PLANNING APPLICATION REPORT

REF NO: LU/71/09/

LOCATION: 7& 9 Norfolk Road
Littlehampton

PROPOSAL: Alterations to frontage and interior to change use of two existing shops to form two new residential units. (Re-submission following LU/7/09/)

WASTE STORAGE PROPOSALS

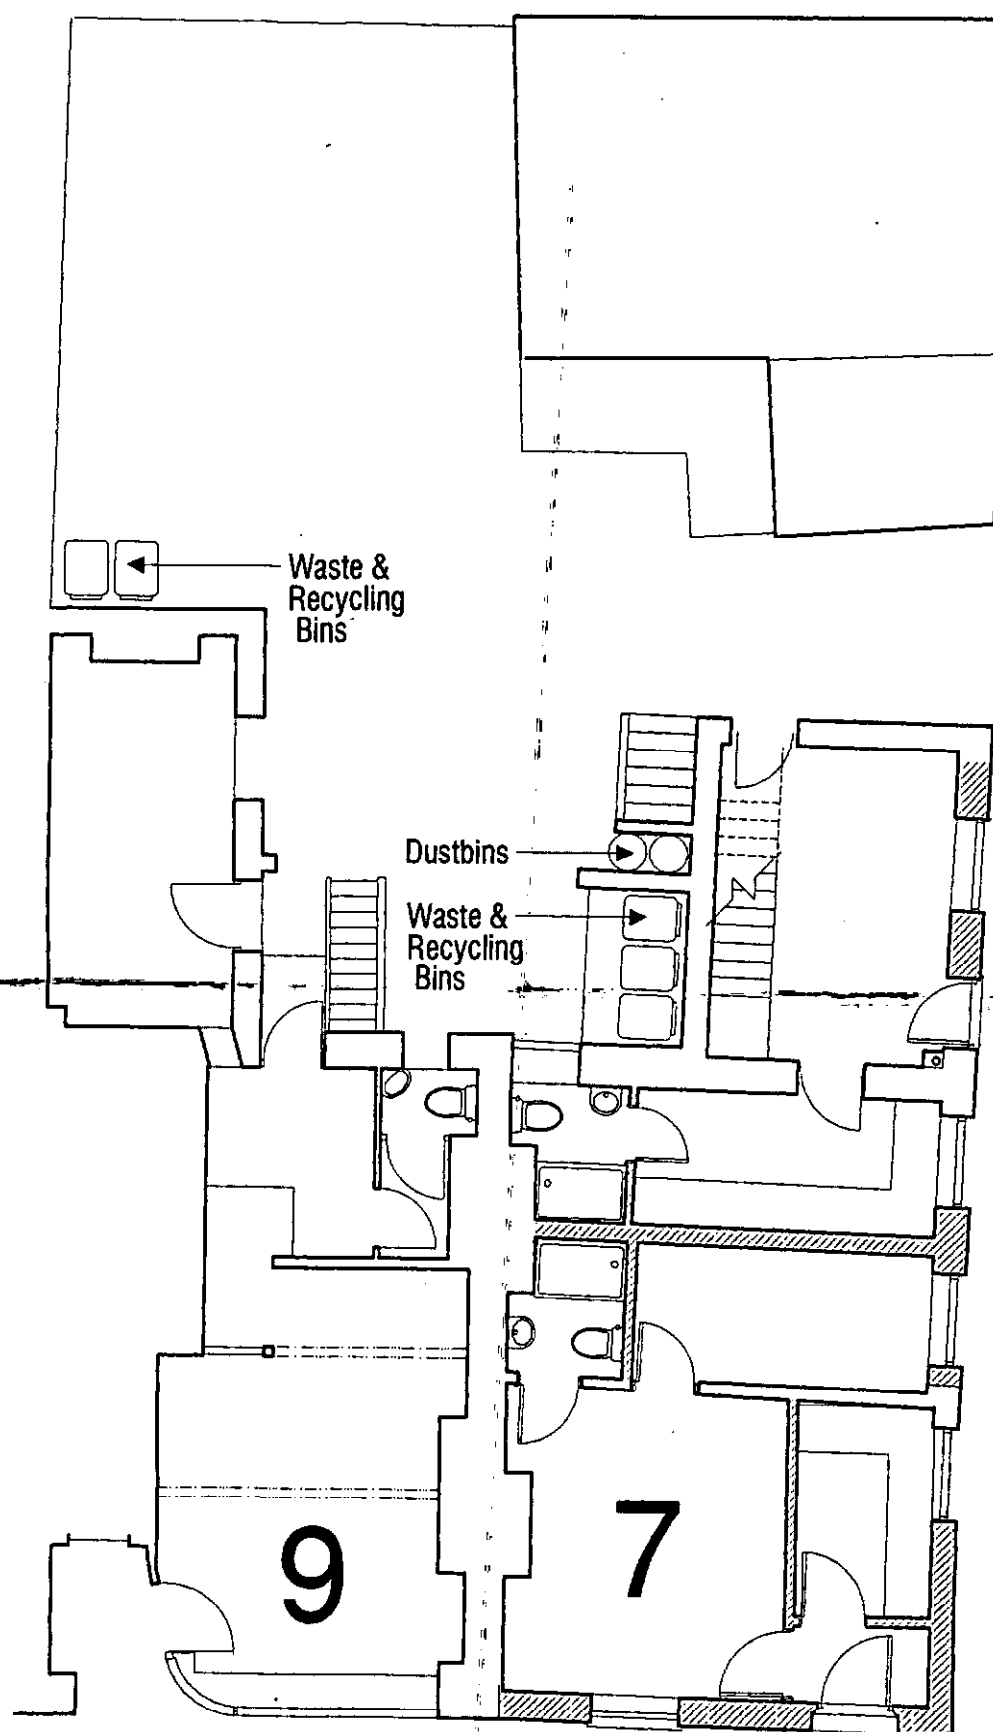
The vehicular access is used for parking already and the most recently available verified accident records reveal that there have been no personal injury accidents in the vicinity of the existing point of access. Parking to the amount of one space per dwelling is provided to the rear of the property on a first come, first served basis and the proposal is unlikely to affect parking to the extent where a highway safety issue arises. Any approval of planning permission would be subject to a cycle parking condition.

The use of vertically sliding PVCu sashes would look out of keeping with the existing building. A recessed front door and recessed windows would look out of context with neighbouring properties. If approved, a condition is to be imposed regarding secure cycle storage.

- 3 The development hereby approved shall not be occupied until covered secure parking spaces have been provided in accordance with a detailed construction plan to be submitted to and approved by the Local Planning Authority.

South Elevation to Western Road

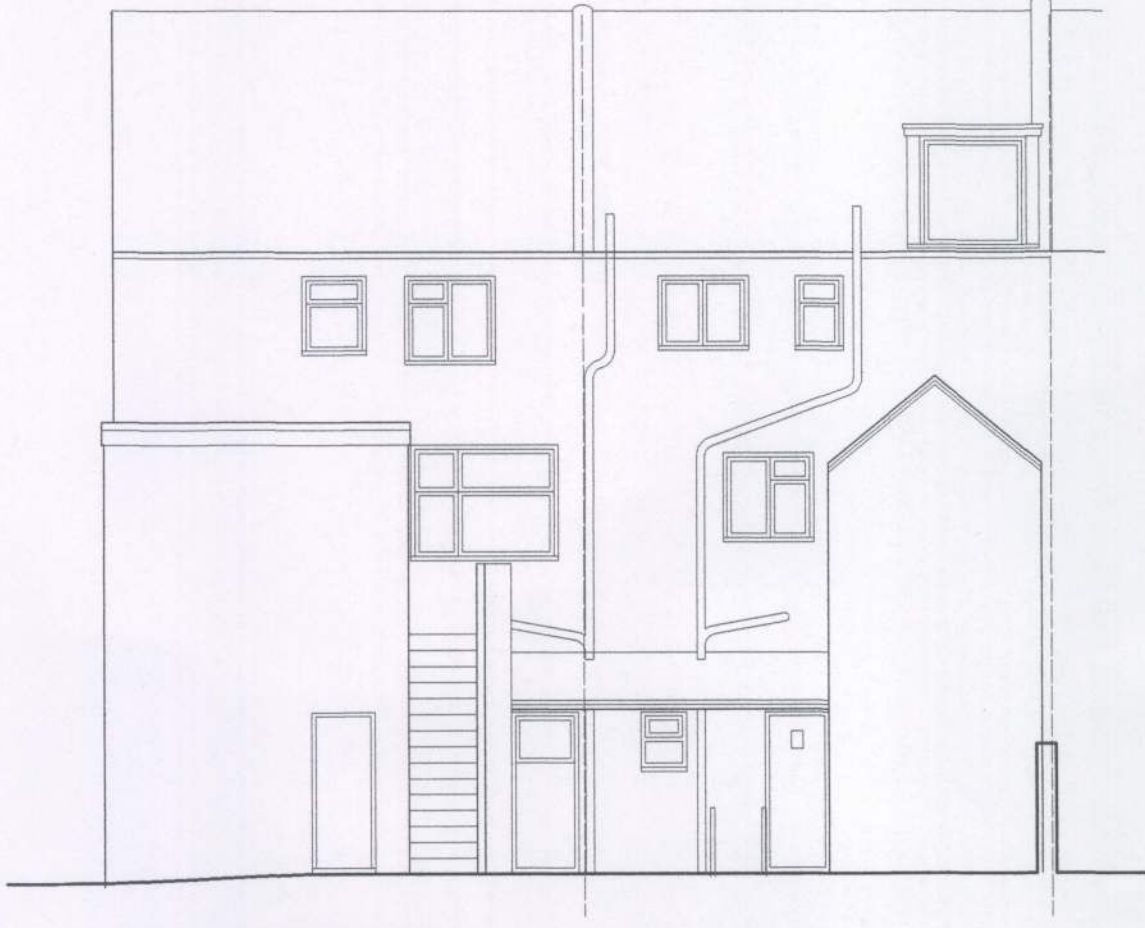
It is a pity to lose the retail uses but if they are not viable then this proposal is a satisfactory use of the building. Do we really have to have top-hung PVCu casements. If there is no reason to resist because the remainder of the building has plastic windows then at least we should be seeking vertically sliding PVCu sashes, particularly since the new windows will be down at street level.

New front door should be recessed and windows.
